# Rezoning Transportation Analysis

Petition Number: #2022-126

**From:** Jake Carpenter, PE  
Jacob.carpenter@charlottenc.gov  
980-221-5675

Date	Description
12-29-22	First Review (TM)
01-24-23	Second Review (DR)
02-23-23	Third Review (DR)
03-22-23	Fourth Review (DR)
4-14-23	Fifth Review (DR)
04-27-23	Sixth Review (TM)

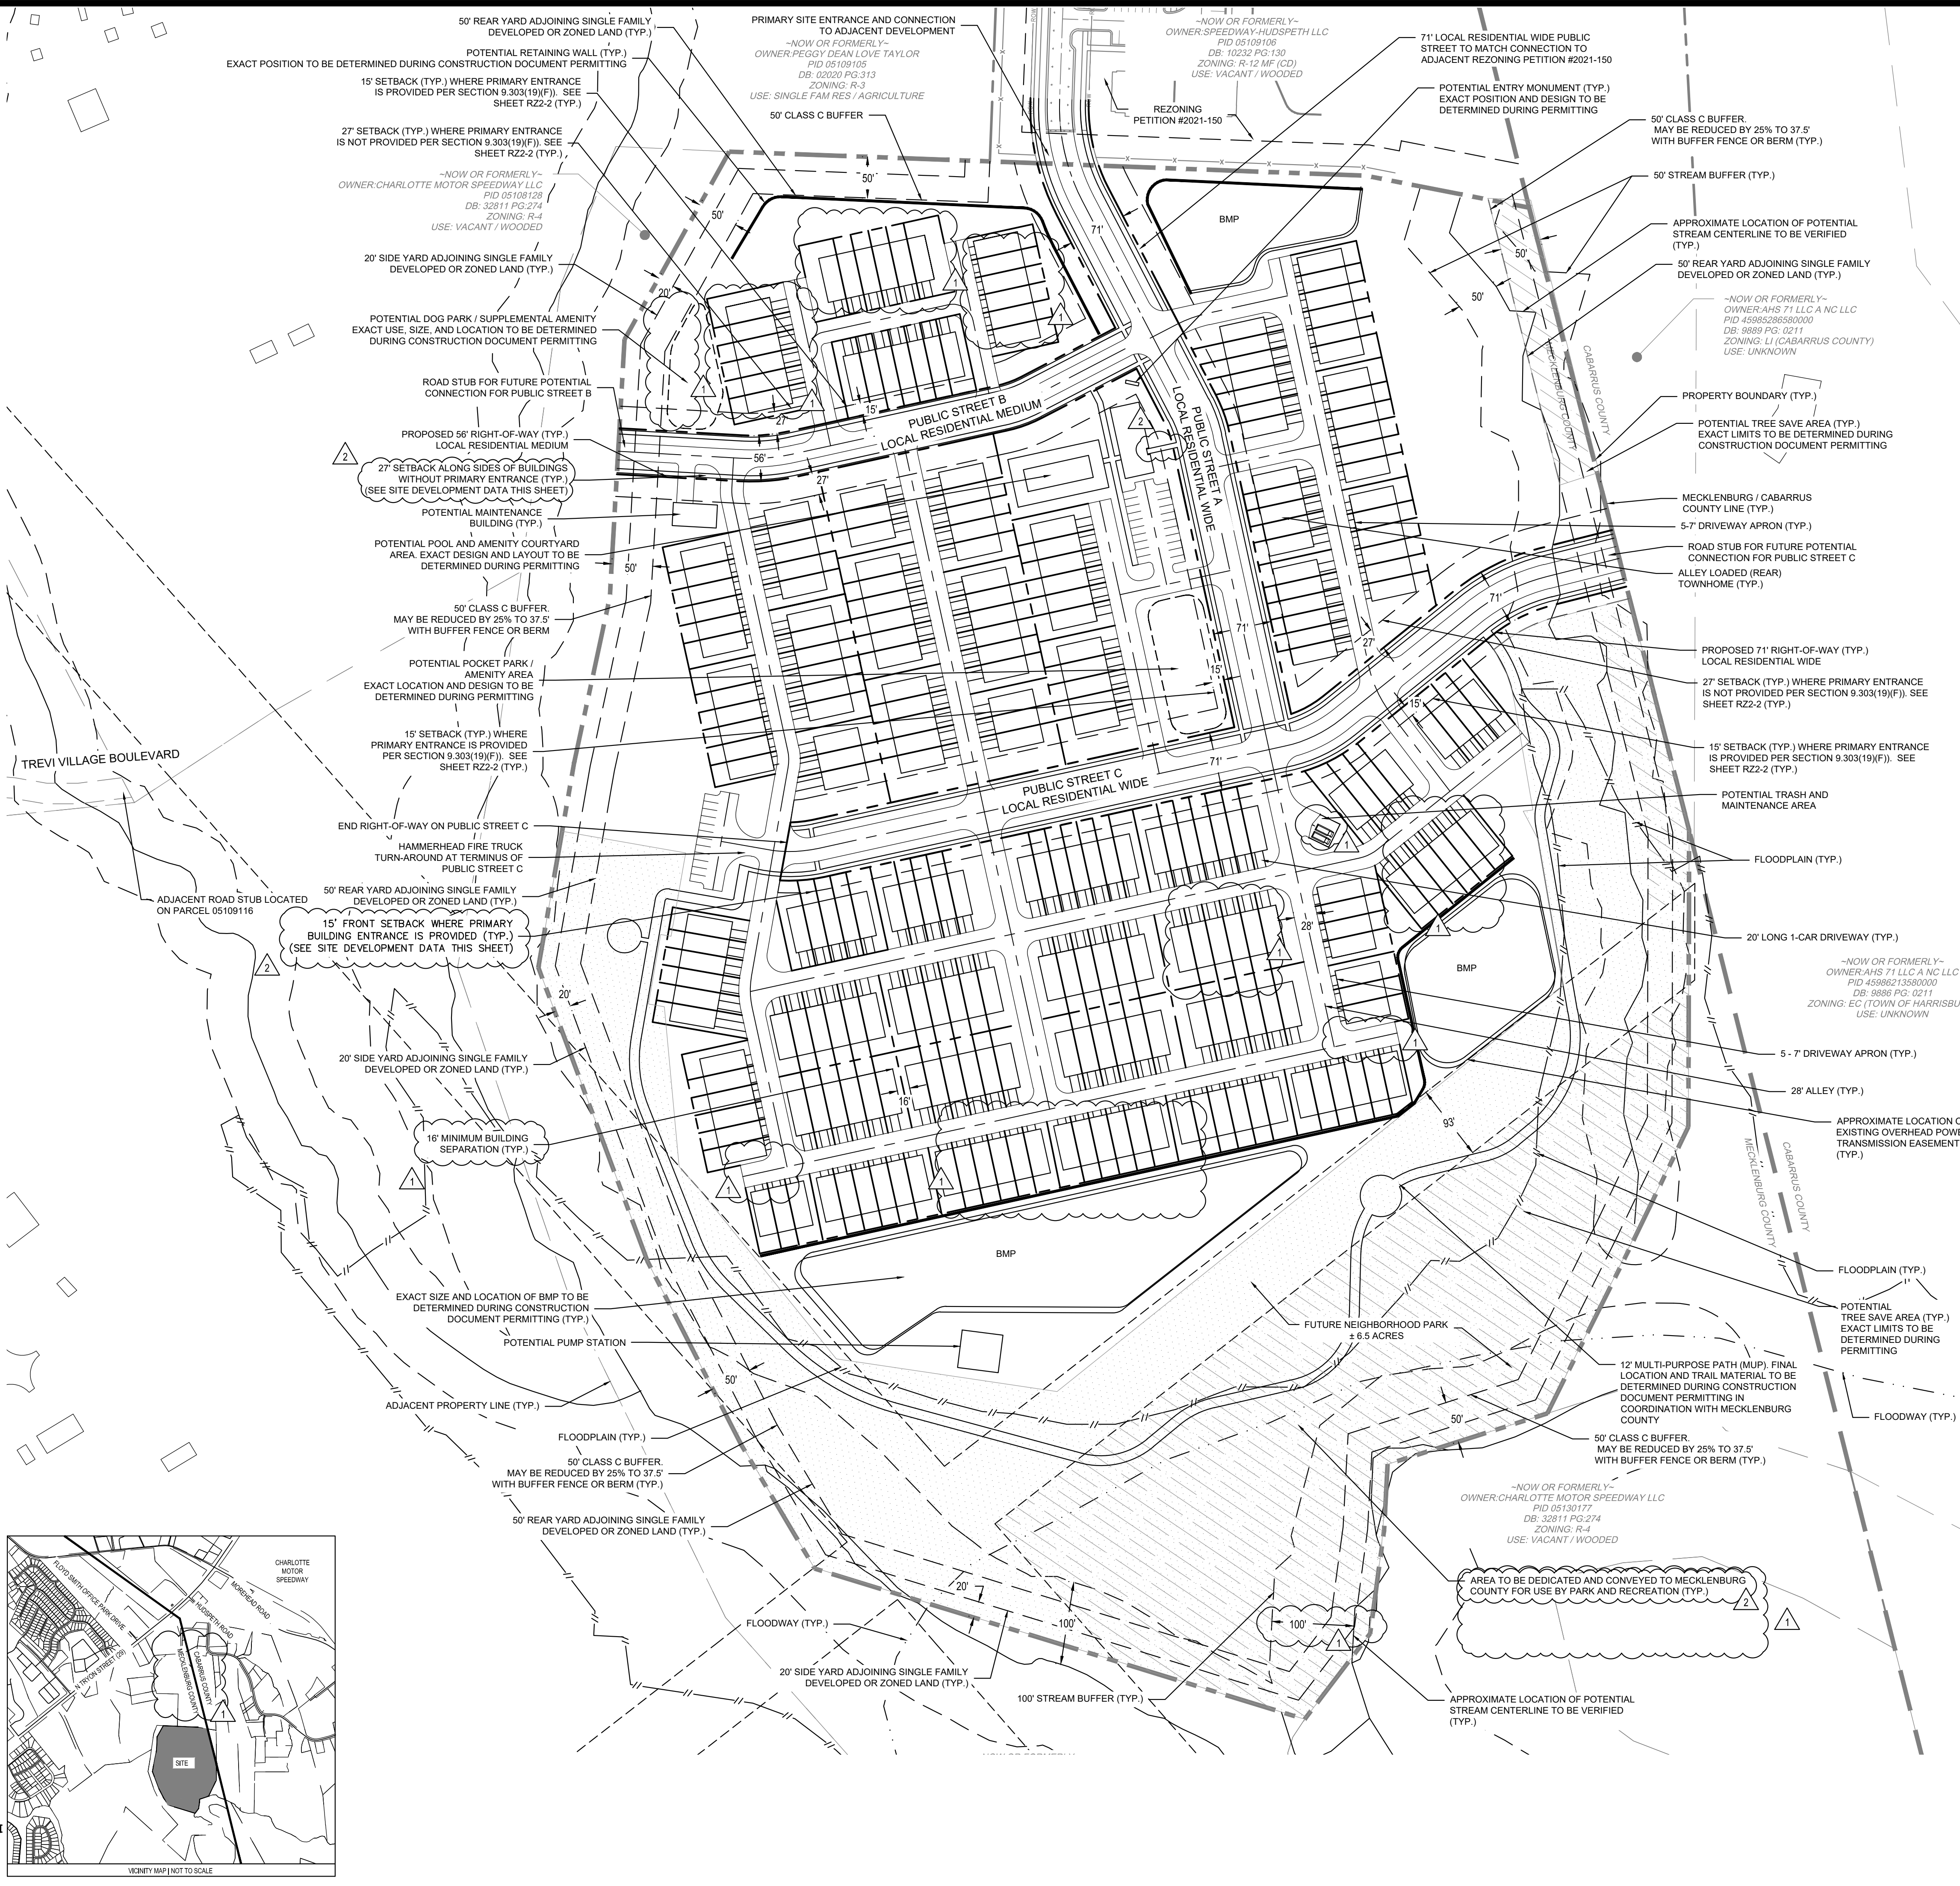
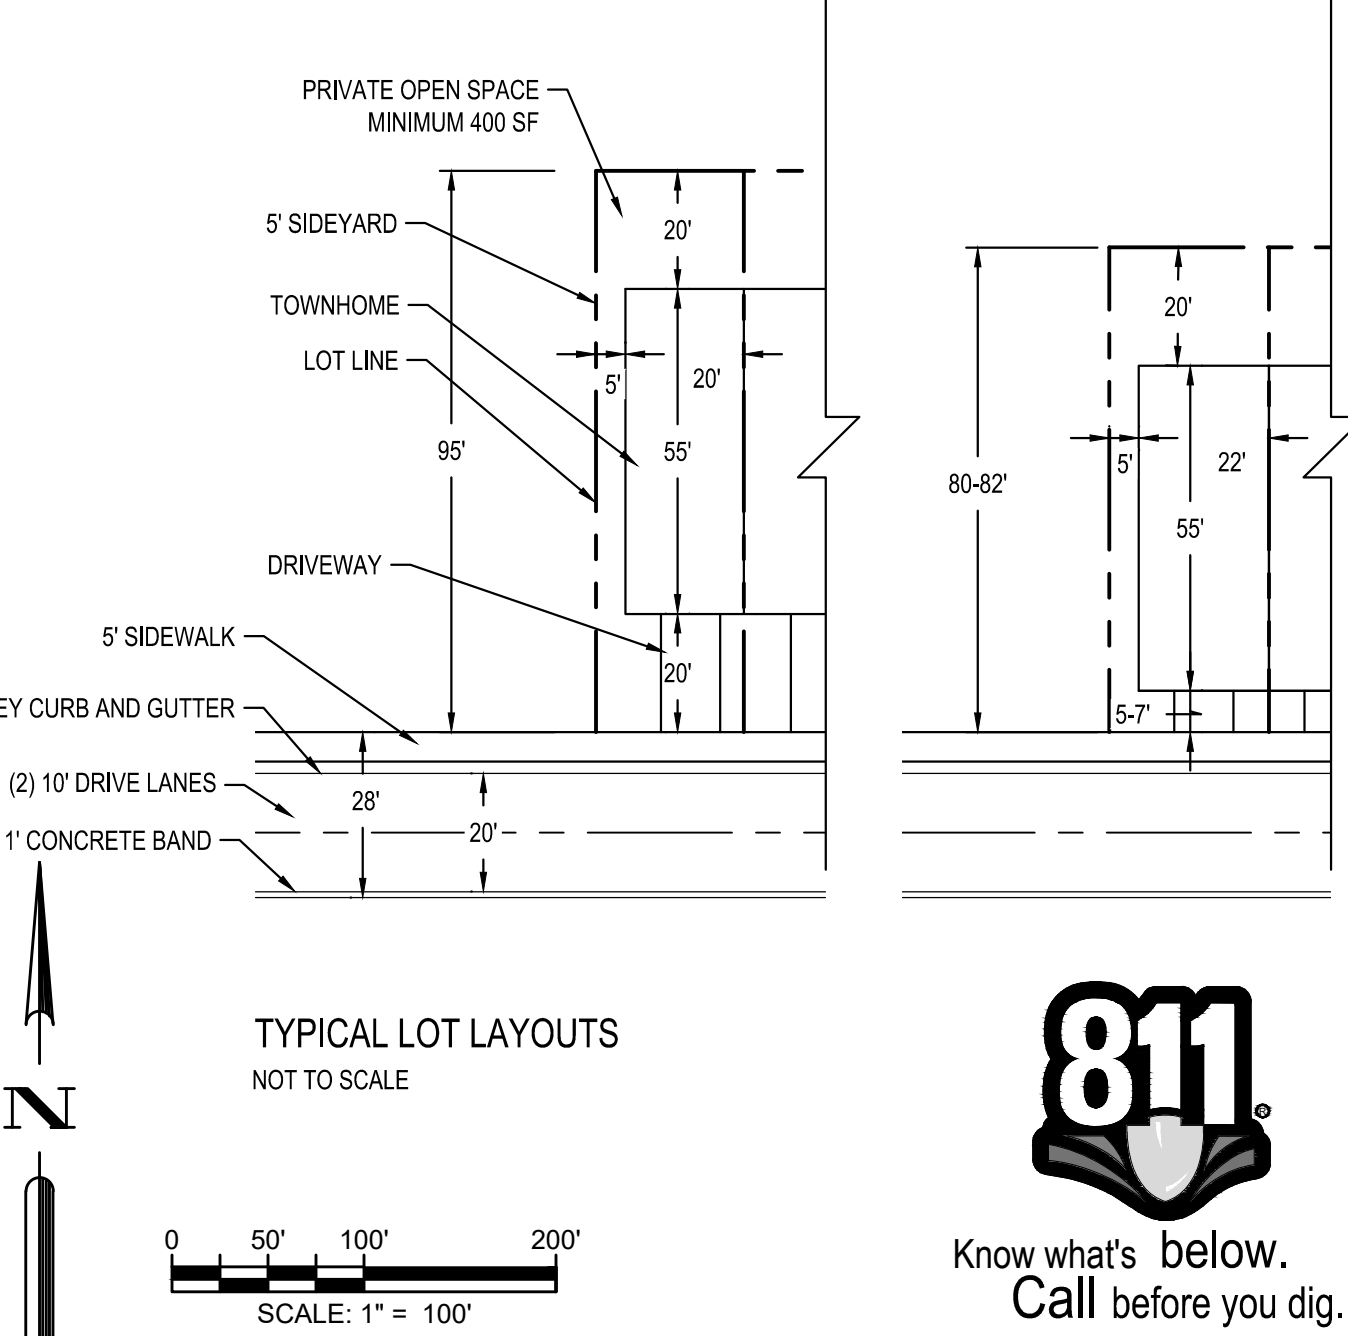
### 4. ~~Show entirety of Public Street A as a Local Residential Wide. Add CLDSM roadway typical section for Local Residential Wide.~~

**Clarifying comment from 1/24/2023:** Add CLDSM roadway typical section for Local Residential Wide (CLDS U-03A) to sheet 2.
